April 24, 2017

**Subject: 1039 Riverside Street, Second Tee Business Park Unit 15
Final Site Plans
Letter of Response #1**

SHEET TITLE  
SITE LAYOUT, UTILITY AND  
LANDSCAPE PLAN

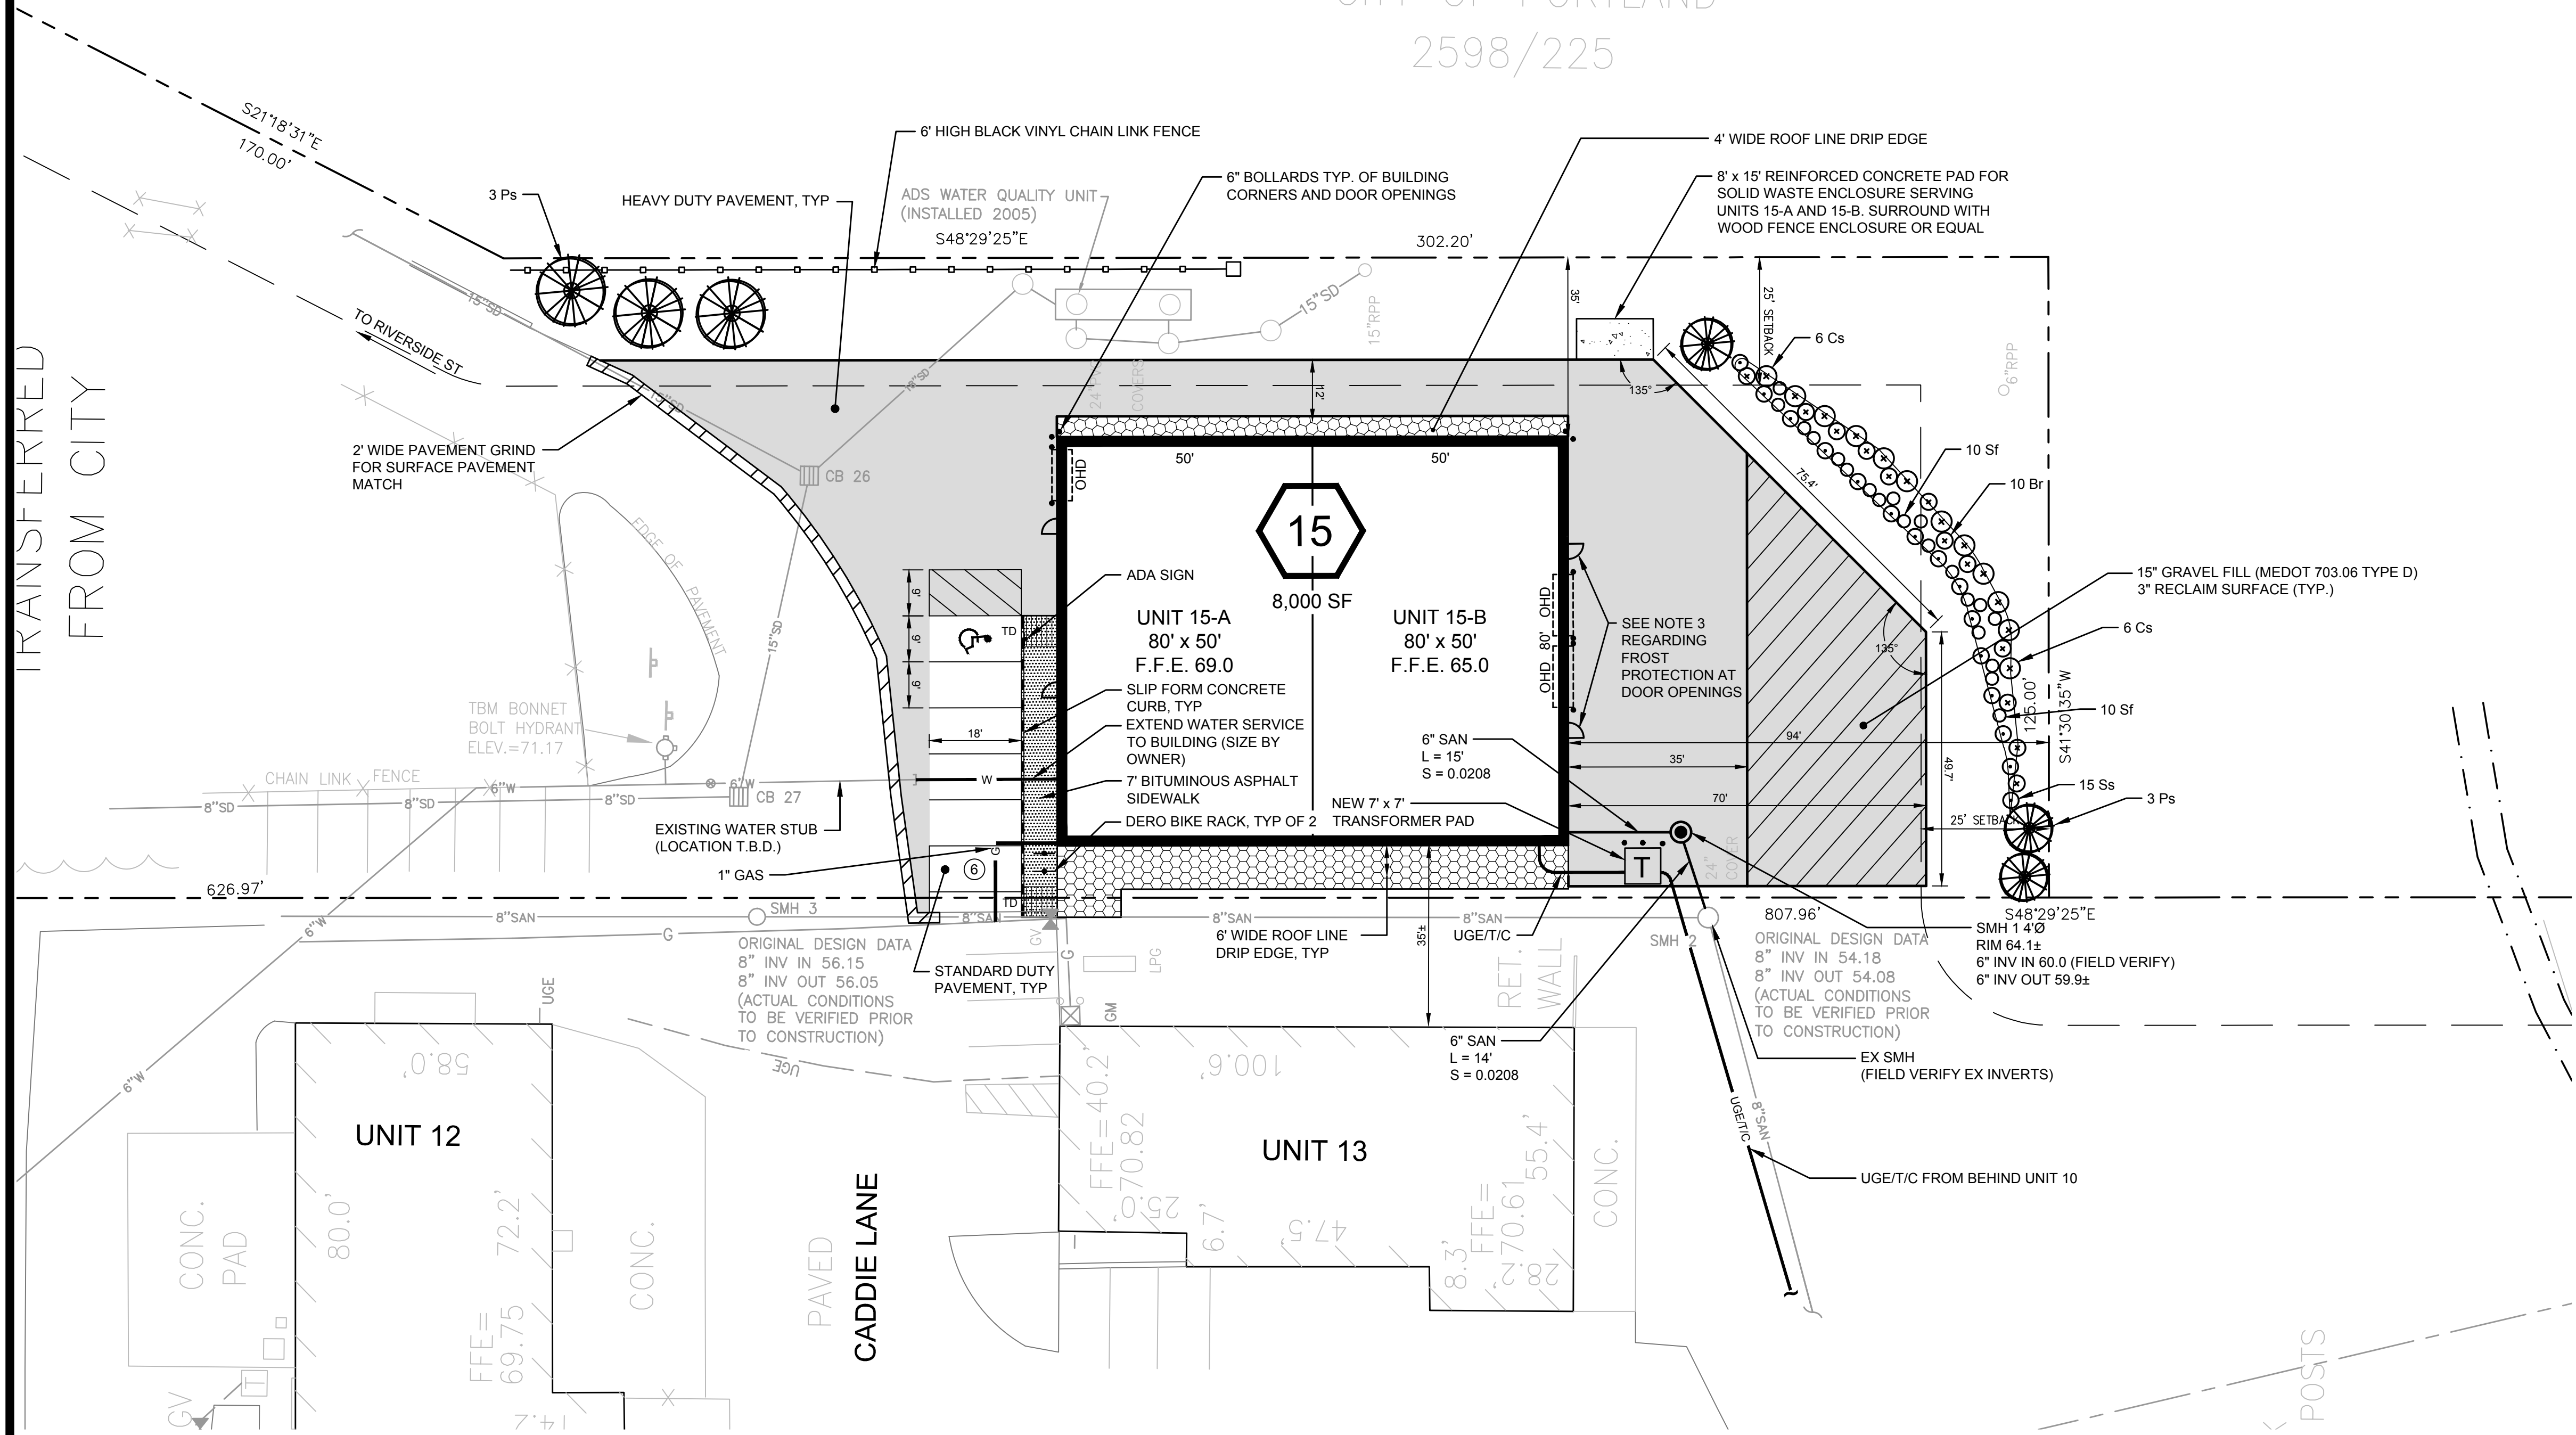
What is purpose of the hatched paved area to rear?

The hatched area will have a surface consisting of reclaim asphalt product, which has been found to be a suitable material that holds up well for this type of application.

SHEET TITLE
**GRADING, DRAINAGE AND
EROSION CONTROL PLAN**

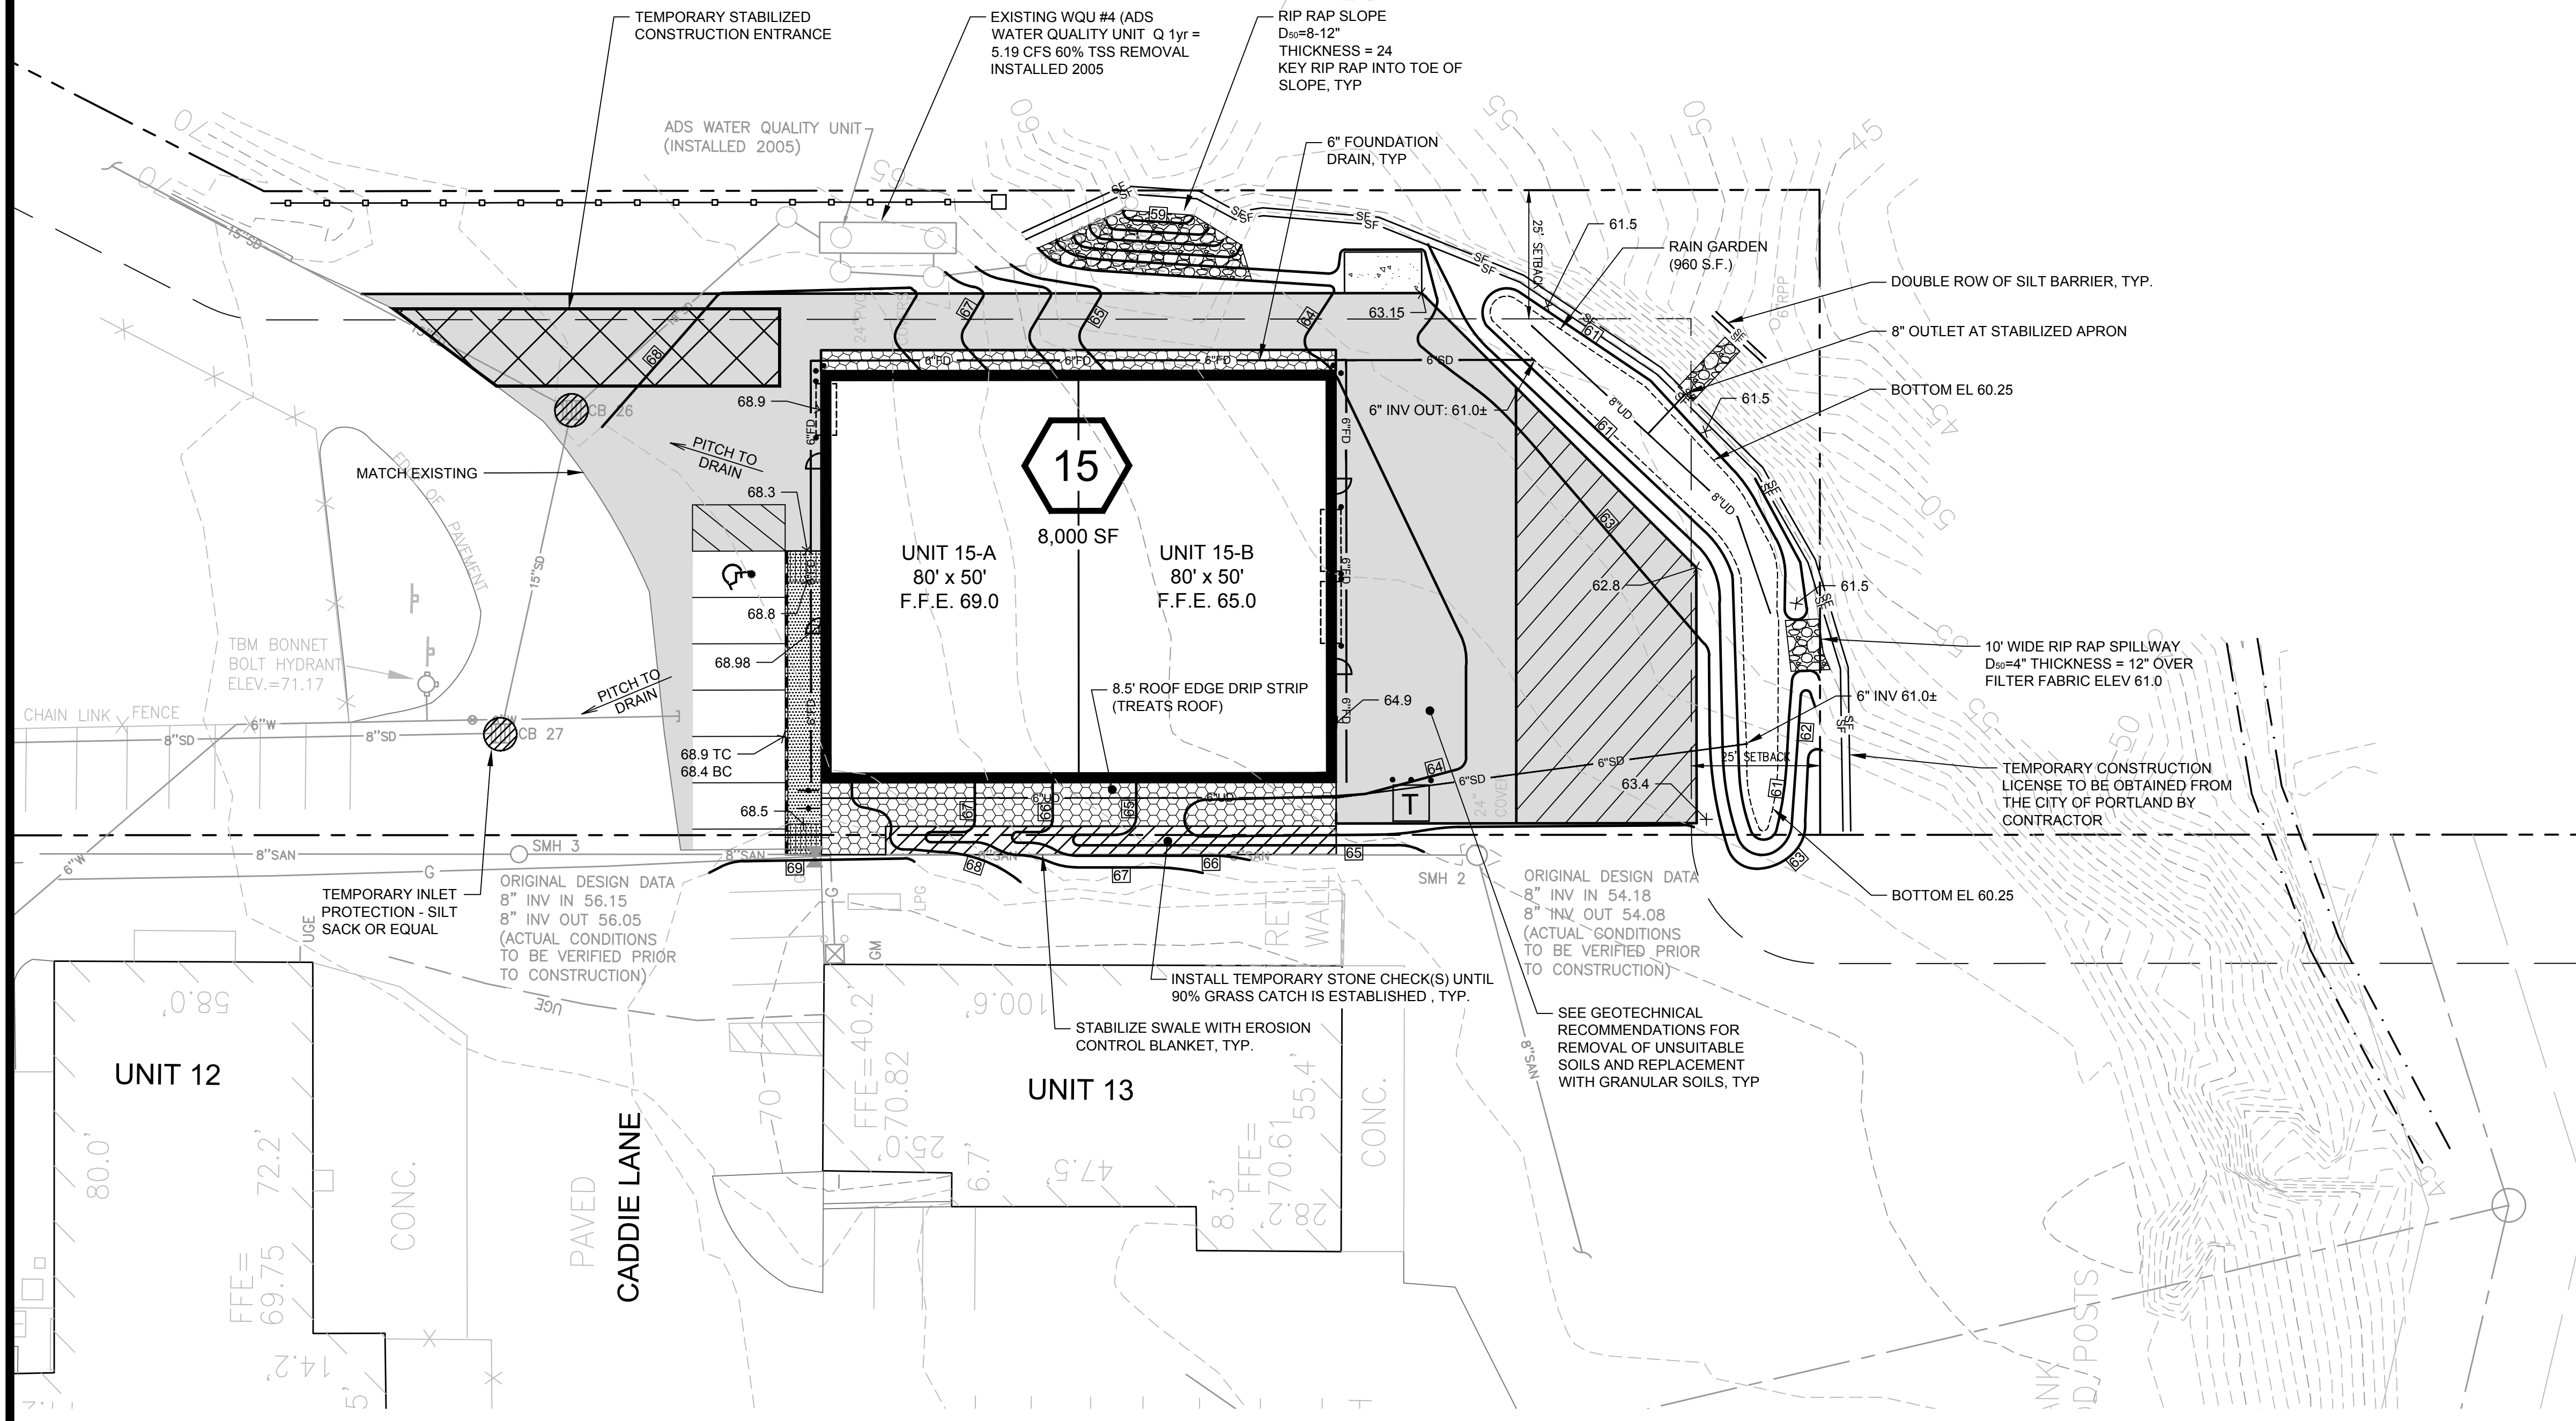
The raingarden at the rear appears to be discharging to a property not owned by the applicant. Does the applicant have an easement or other permission to do this (relates to questions below about this area)?

We believe that the discharge from the rain garden basically mimics the current natural drainage pattern for release of runoff from the site area. There is a small onsite area that allows for any discharge to disperse before entering the natural gully that bisects the business park. The City of Portland owns the property, so the need for any further easement for these natural drainage conditions seems unwarranted in our opinion.
